Job No. 192628

May 3, 2024

Re: Response to CGS review comments (dated October 17, 2023) and El Paso County Planning Department comments (not dated)
Meadowlake Industrial, Filing No. 1
Section 9, Township 15 South, Range 65 West
El Paso County, Colorado

PRELIMINARY PLAN
SITE PLAN

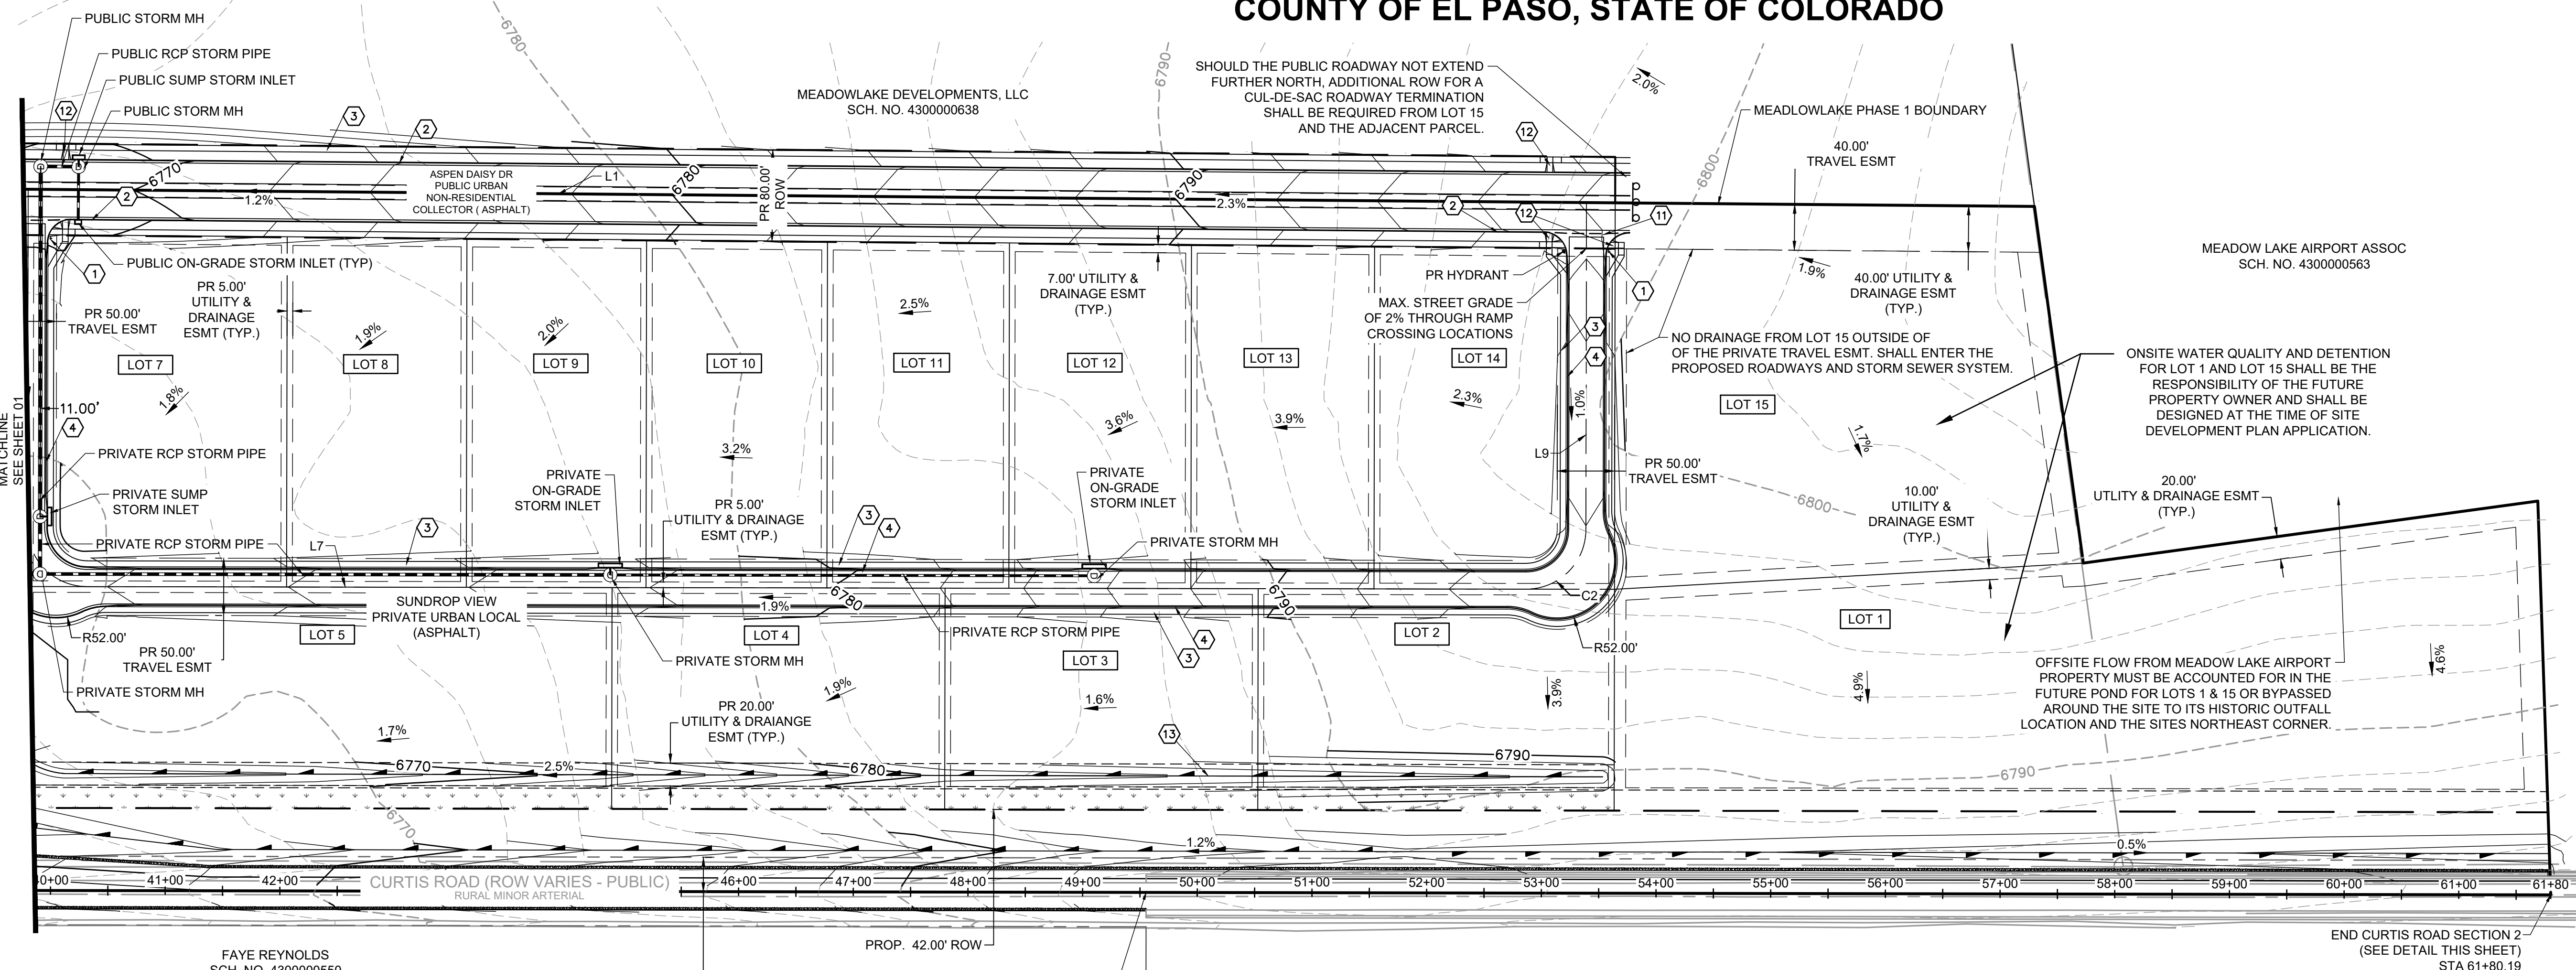
2. A note should be added on the preliminary plans that no inhabitable below-grade or basement areas will be allowed unless shallow groundwater conditions have been addressed with a monitoring program through all four seasons combined with a discussion of regional precipitation trends that can periodically increase the fluctuations expected in groundwater elevations. This evaluation can determine if underdrain systems will be needed and if they can be placed during the planned over-excavation for swelling and compressible soils and bedrock.

4. The Geologic Hazard Note on the preliminary plan (HR Green, August 25, 2023) should also include expansive and compressible soils as geologic conditions present at the site.

A note has been added to the preliminary plans that no inhabitable below-grade basement areas will be allowed unless a year-long ground water monitoring program has been completed.

It is our understanding the Geologic Hazard Note has been updated.
